From: David Easton
Sent: 20 December 2017 09:19
To: Karen Parsons
Subject: FW: A/155/17/OUT - Avenals Barn, Angmering
Attachments: Proposed dwellings - Plan Elevations.pdf; Proposed dwellings - Site plans.pdf

Subject: A/155/17/OUT - Avenais Barn, Angmering

AR-122-01

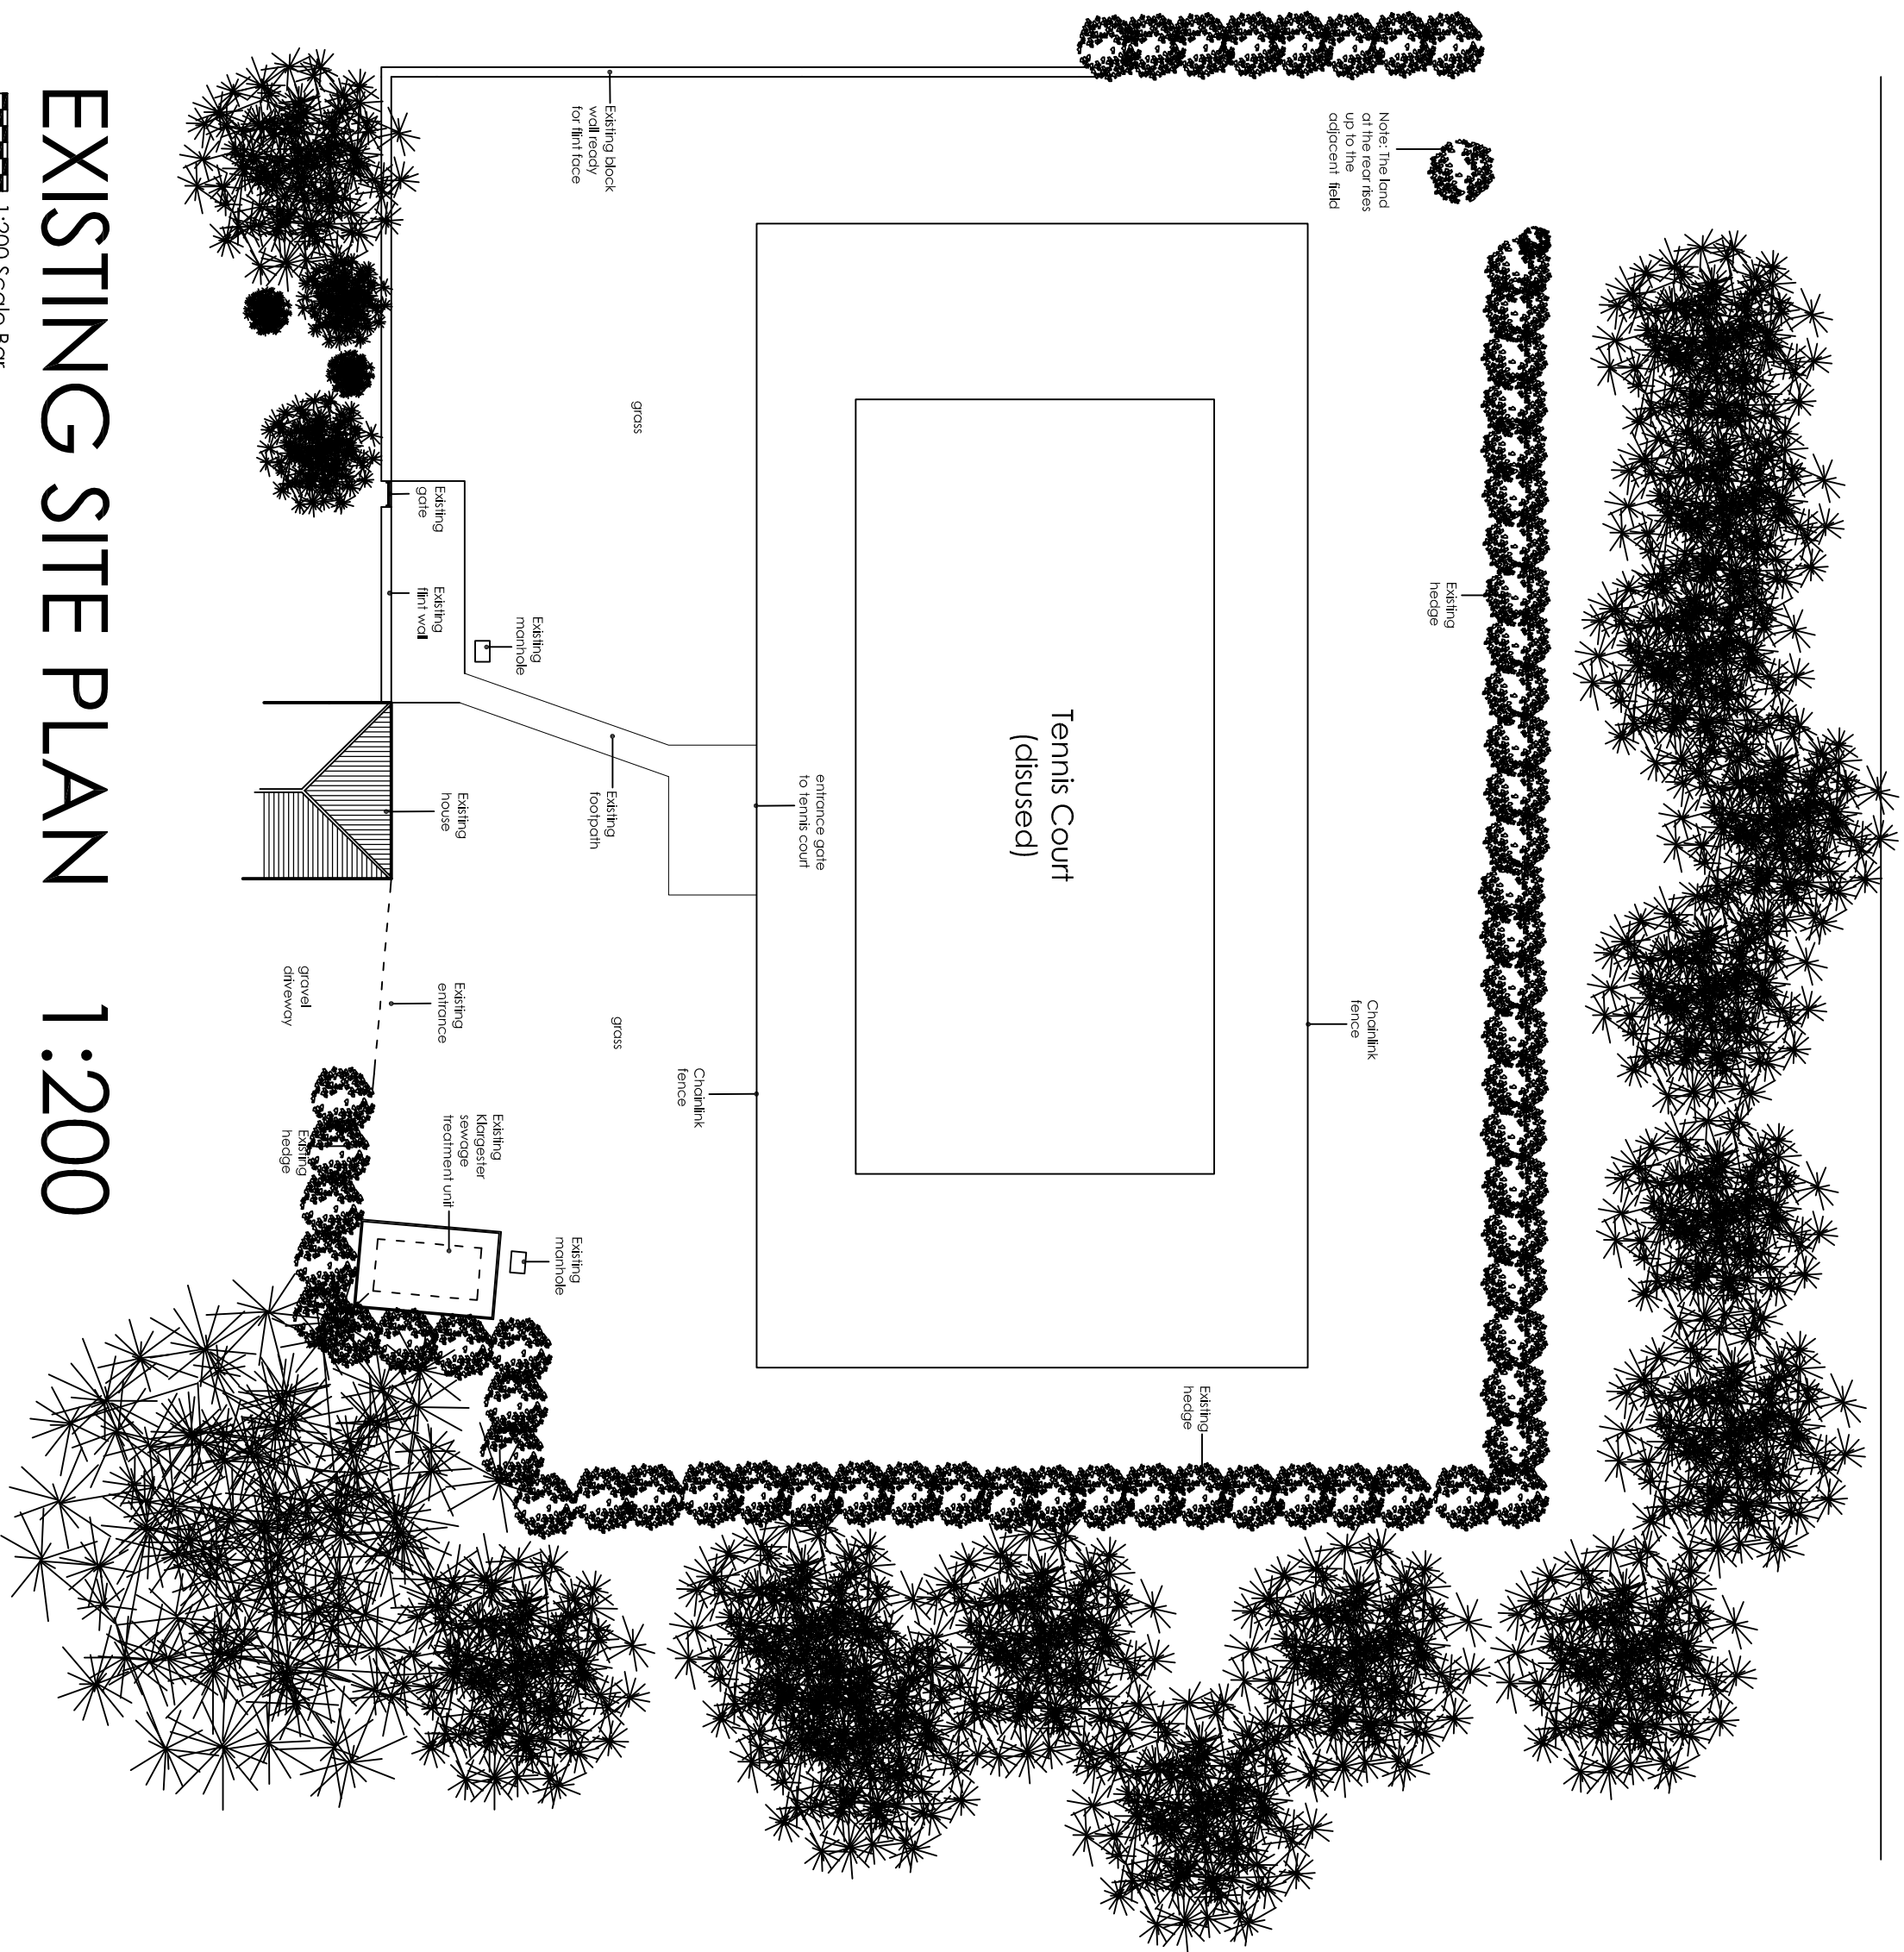
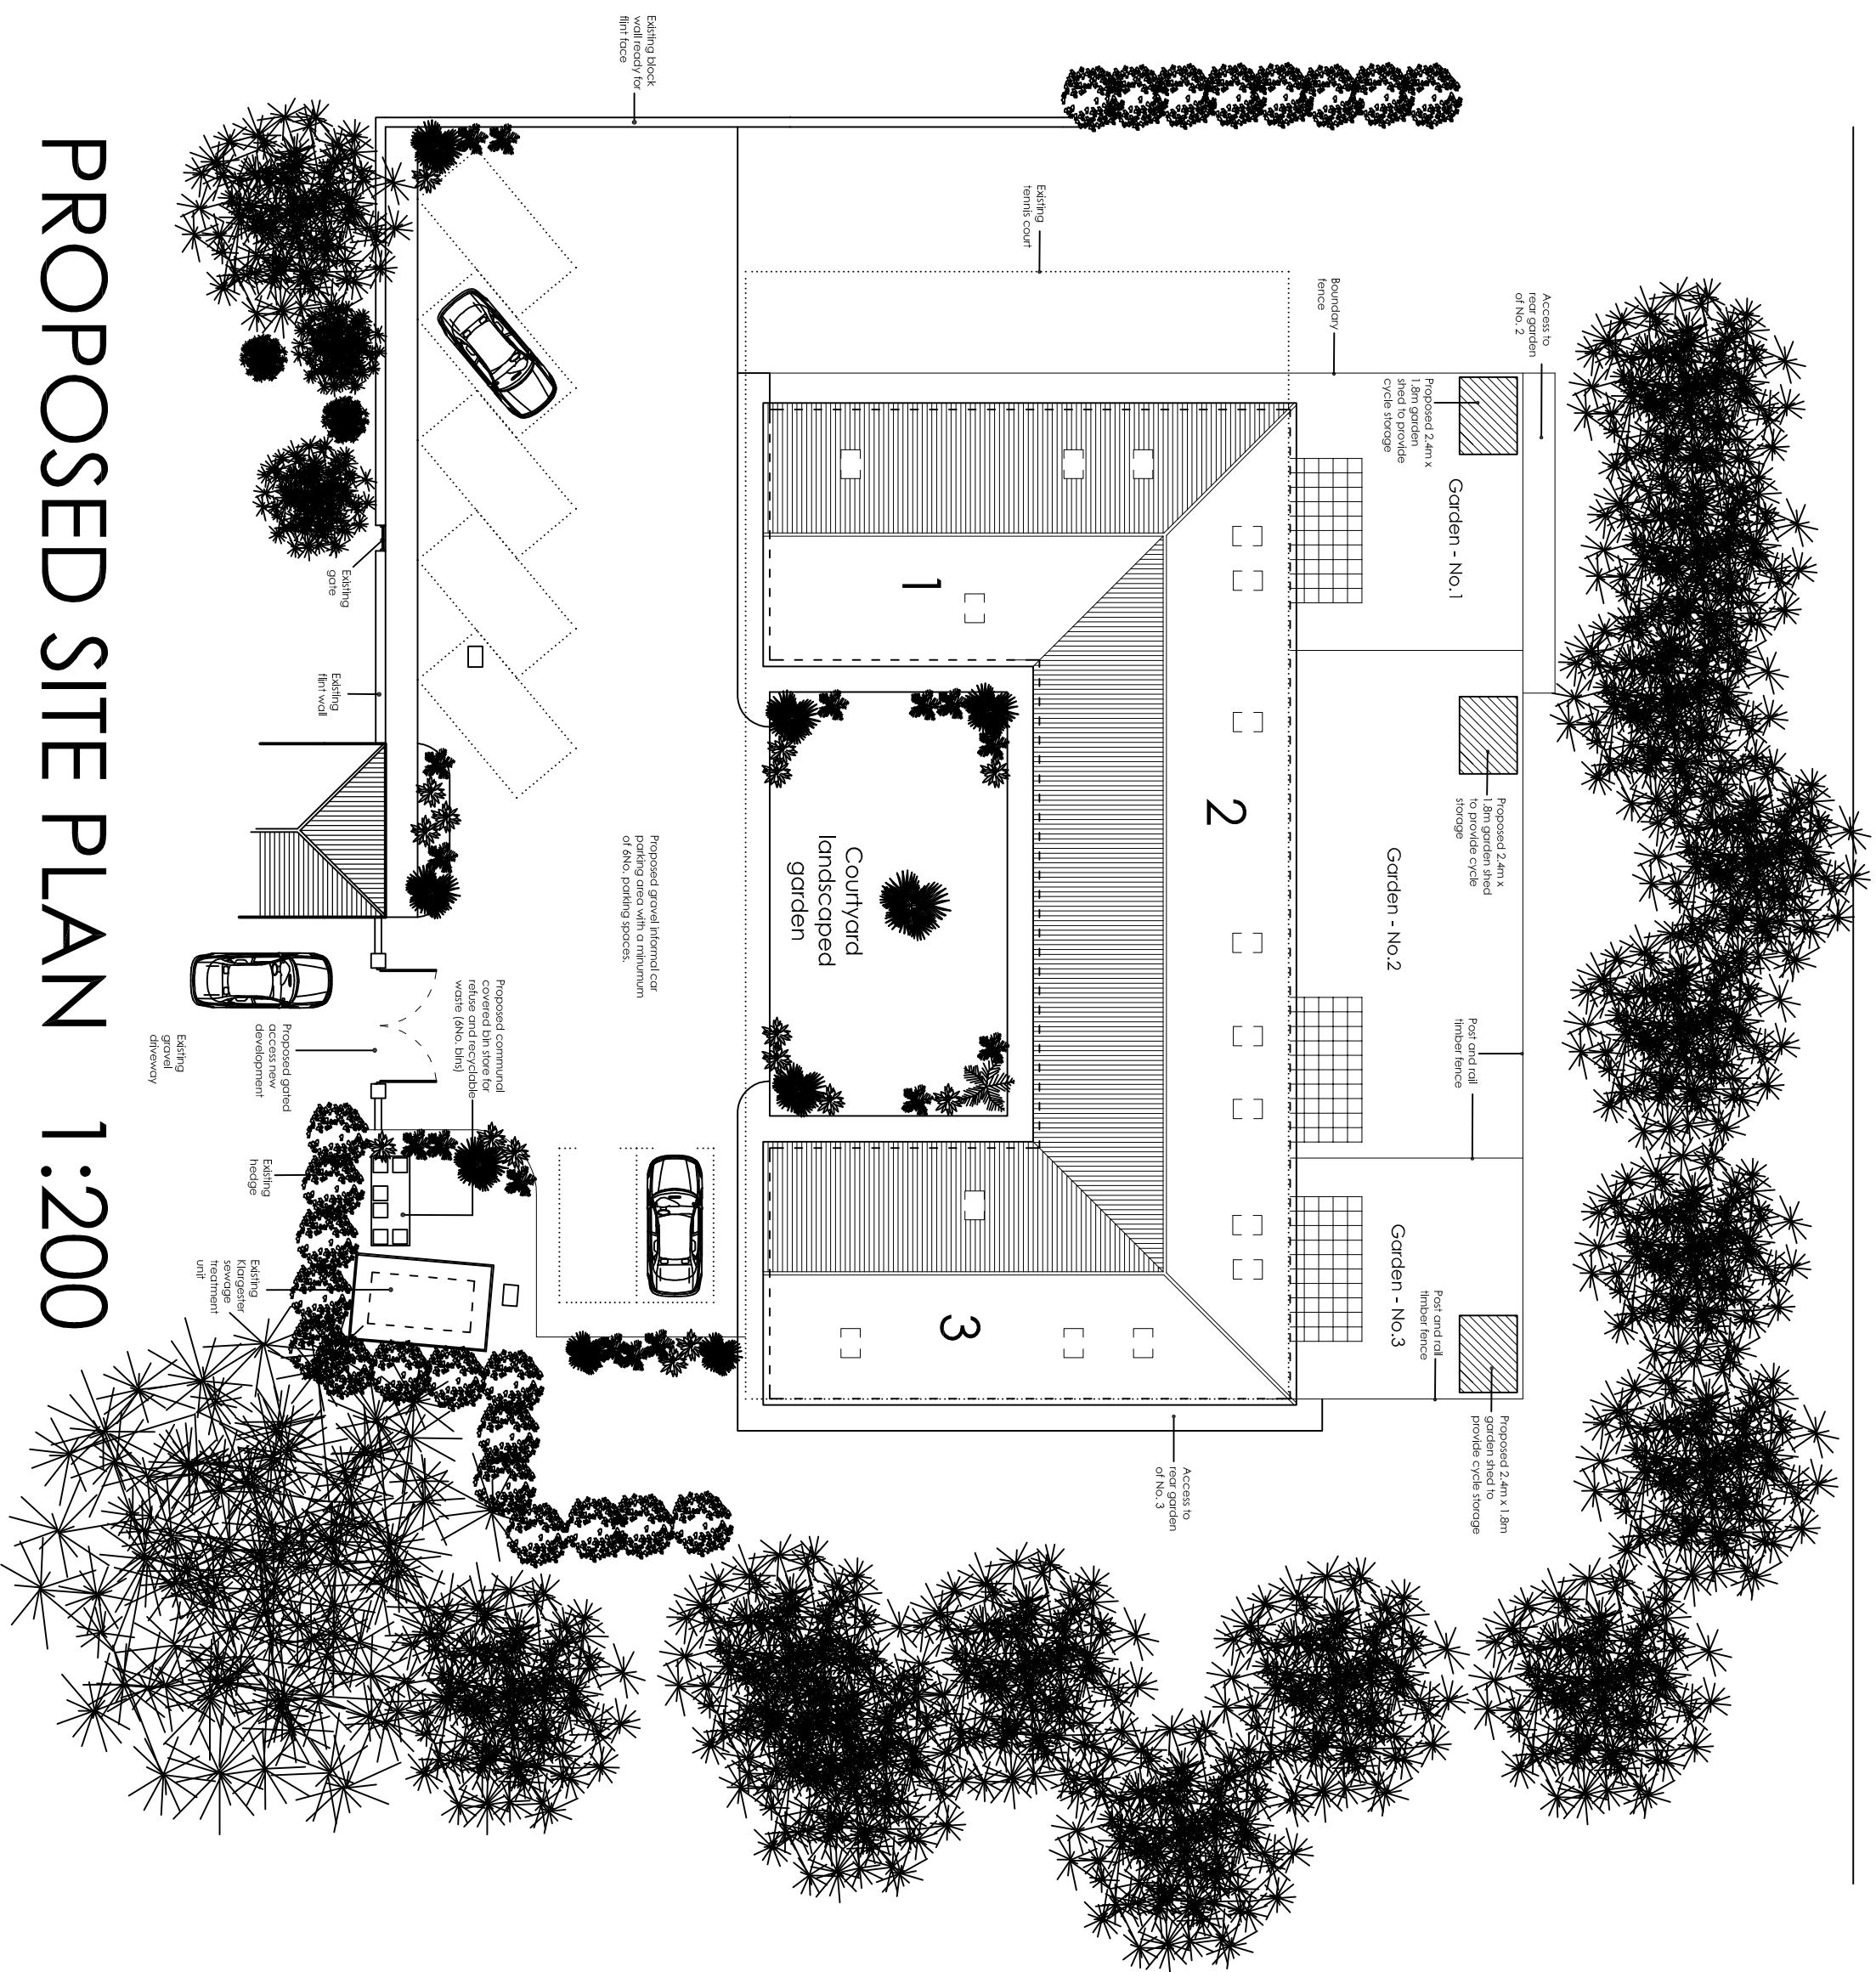
As discussed the major concern held by the Council at this time relates to the severance of the site due to the absence of a pedestrian footway along Water Lane. Therefore, despite the distances being considered acceptable the absence of this pedestrian link prevents the site from being considered sustainable. However, following our discussions you have advised that the applicant in this case owns the land to the west of the application site and as such the red edge could be extended to Weaver's Hill to provide a pedestrian link into Angmering. Therefore, I would advise that an location plan is submitted to allow the LPA to secure this pedestrian link.

I have also advised that some concerns exist in relation to the garden sizes of Plot 1 and 3 and as such recommend that some consideration is given to how best to meet the requirements of policy D DM3 of the emerging Local Plan.

1. The depth of the rear gardens have been increased to 10m
2. In order to provide sustainability, a footpath / cycle link has been included to Weavers Hill. Please note that the client owns this plot of land and therefore the blue line has been extended around the field.
3. The patio door to the front elevation has been removed and replaced with 2 windows. The patio doors will only be seen from the rear of the property.
